# LOT 1 WOODMEN HILLS FILING NO. 12

Sheet Title:  
**SITE PLAN / COVER SHEET**

# Site Development Plan\_V2.pdf Markup Summary

FRONT ELEVATION

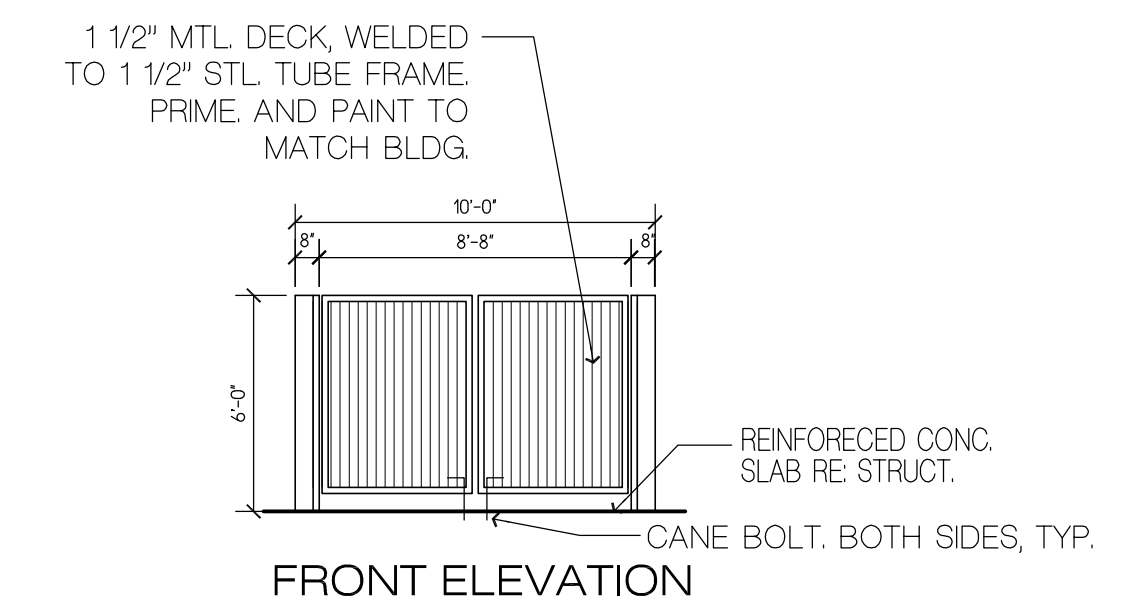
Please refer to the trash enclosure detail on the elevations sheet (sheet 8):

"proposed trash enclosure, refer to Elevations Plan Sheet 8"
